Our Ref: SB-MTWQ1

Portishead Branch Line – MetroWest Phase 1

Below are the North Somerset Levels Internal Drainage Board's answers to the Examining Authority's written questions and requests for information (ExQ1) Issued on 26 October 2020.

Drawing
PORTISHEAD STATION CAR PARK
LAYOUT, LANDSCAPING AND NEW
BOULEVARD AND ACCESS PLAN
SHEET 2 OF 3

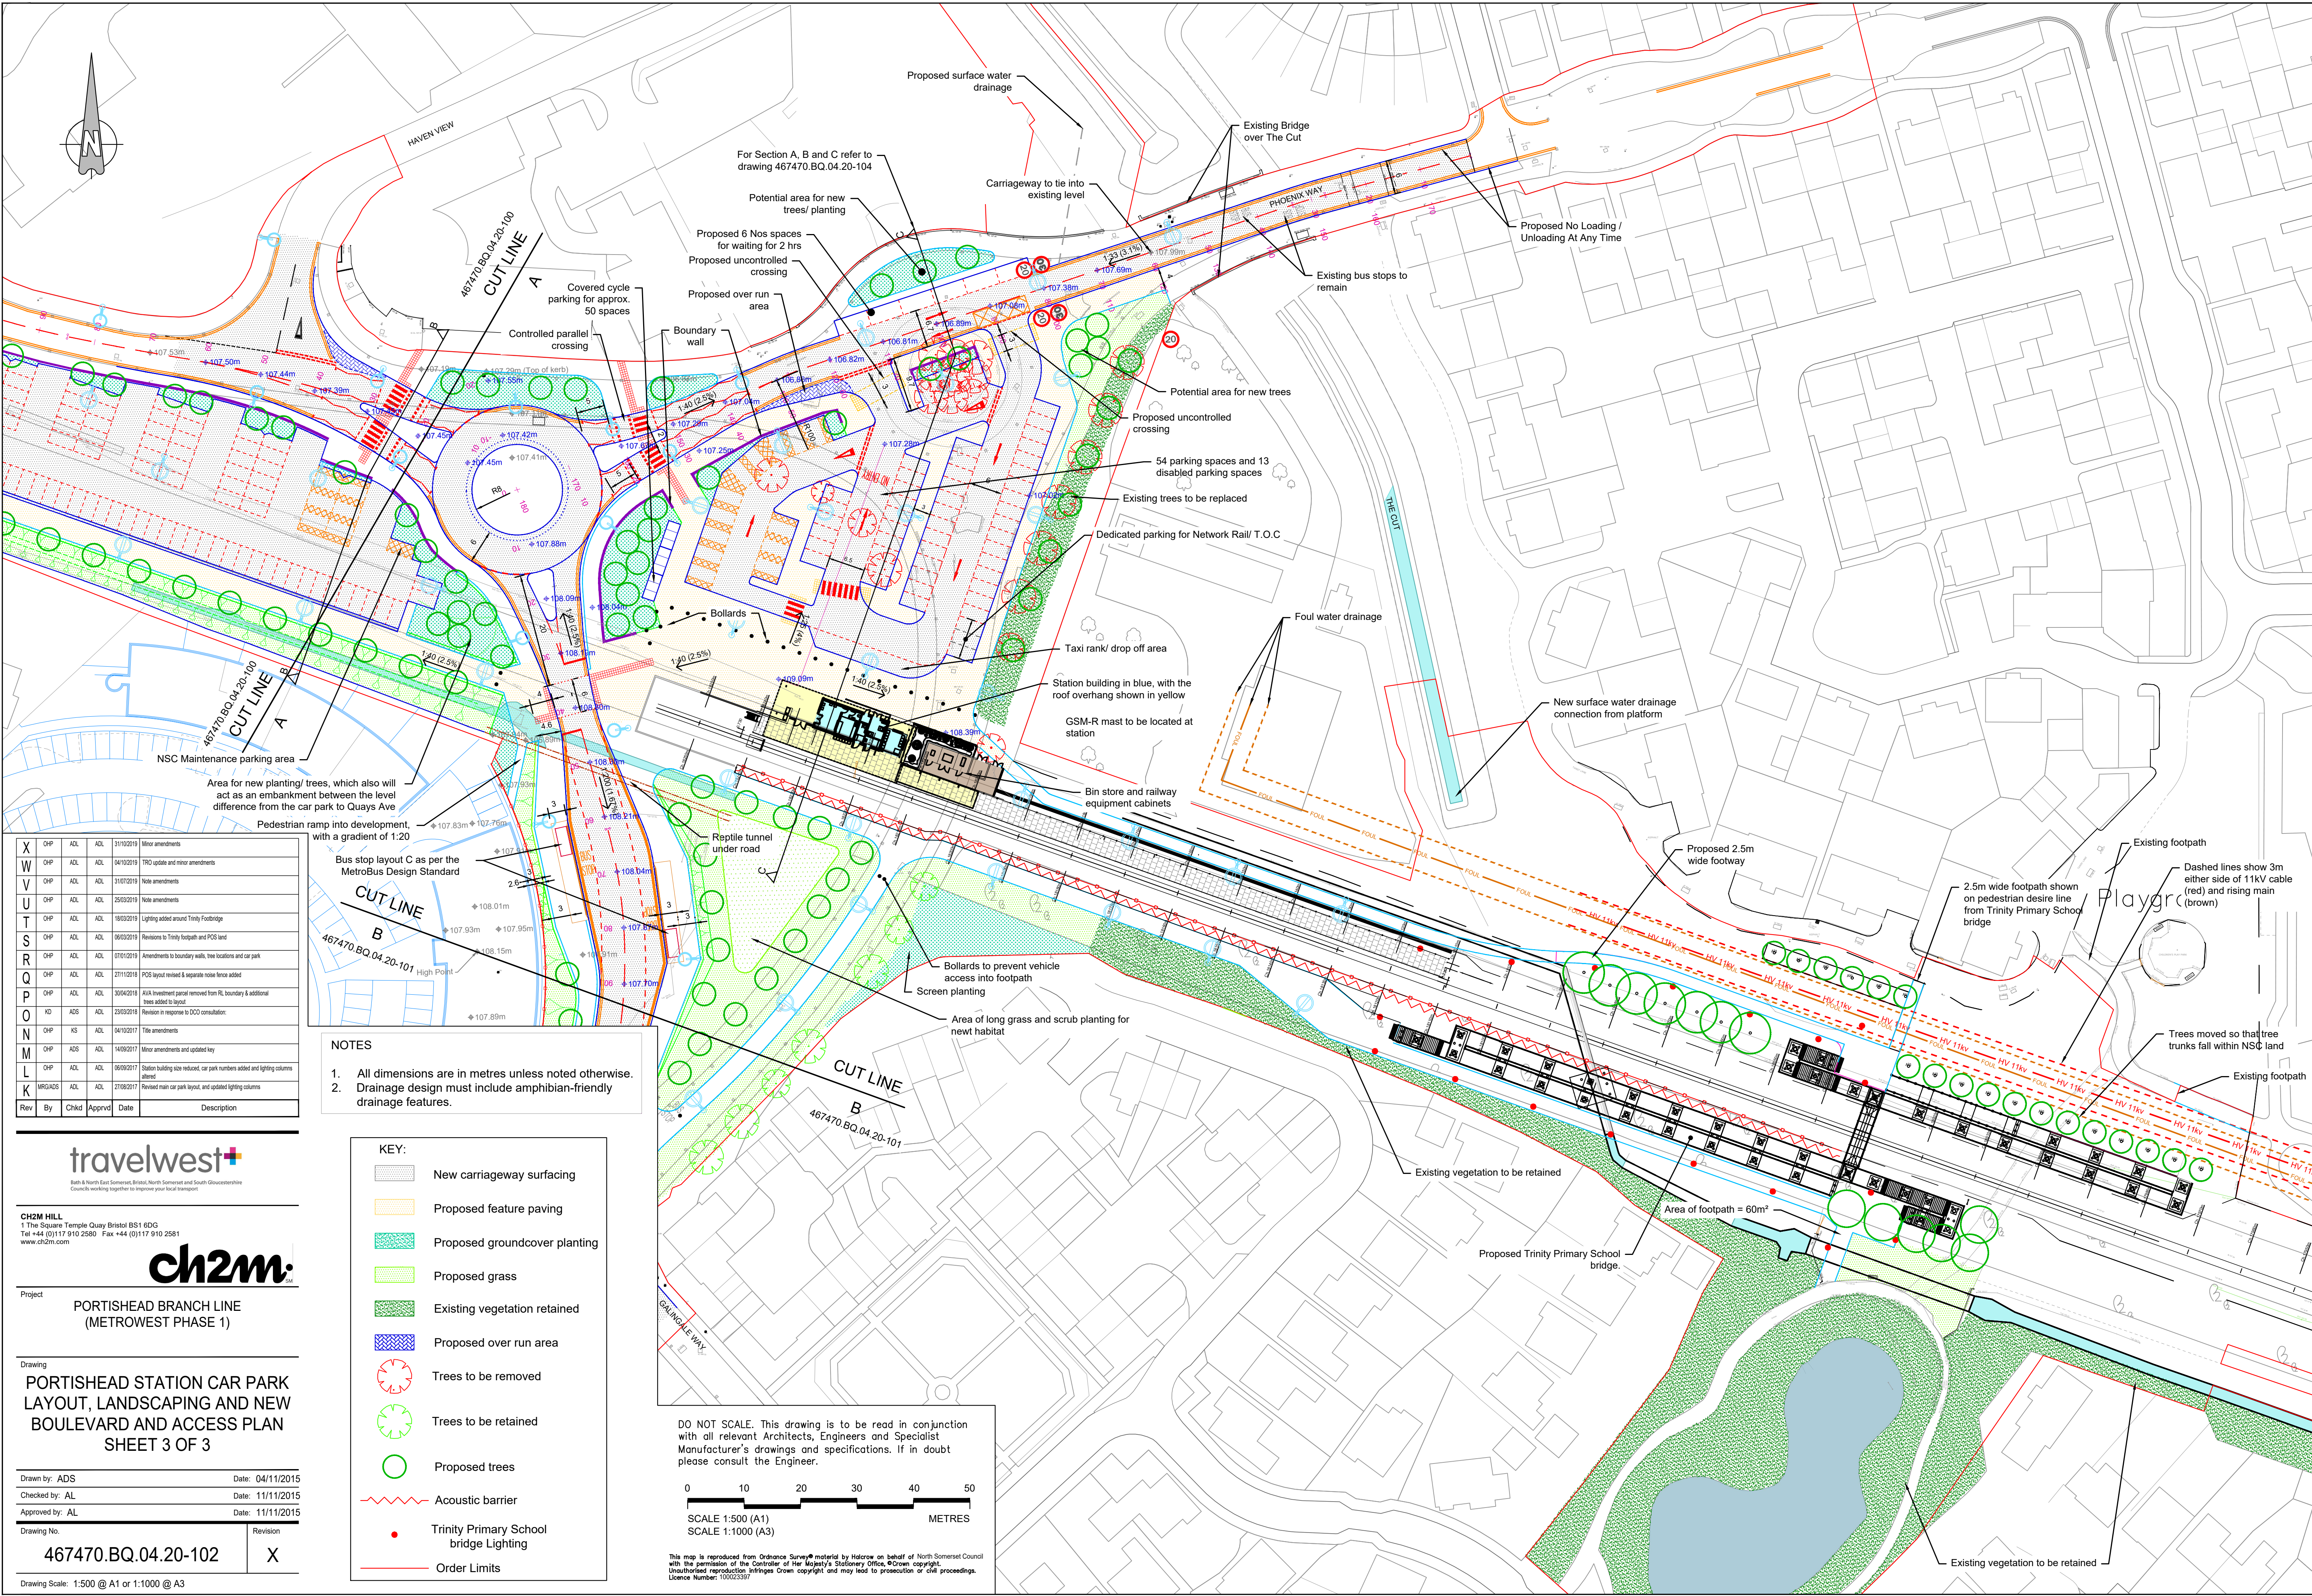
In the location of the Portishead station footbridge and the Board's maintained watercourse known as The Cut (between Galingale Way and Tansy Lane), the applicant's current drawings are partly based upon ordnance survey mastermap data which only is accurate to the nearest metre, and individual features such as watercourses are not accurately surveyed. The top of the bank (a position which is critical when considering safe operational maintenance activities) is not shown. The Board would wish to see a topographical survey of the watercourse undertaken and a more accurate drawing and cross-section of this area provided. This will enable a precise assessment of the space between the top of the watercourse and the railway fence to see if there is enough space for the Board to undertake its statutory duties. For safety reasons, this surface must be flat, and the current drawings do not provide enough level information to determine if this can be achieved. The Board would also want further detail on any street furniture including lighting columns, kerb details, proposed tree species and associated tree pit details. The applicants drawing 467470.BQ.04.20-SK110 rev 8 also incorrectly refers to the batter of a watercourse as being an 'area of grass suitable for excavating vehicle to occupy' which clearly it is not as the drawing does mark the top of the bank (ToB).

The Board has no issues with the railway fence in the location shown in red on 467470.BQ.04.20-SK110 rev A and that provides a similar (not the same) level of access to which the Board has now, but this is subject to the detailed design of the landscaping, lighting, surfacing, levels and any non-network rail fencing and the accuracy of the currently presented information.
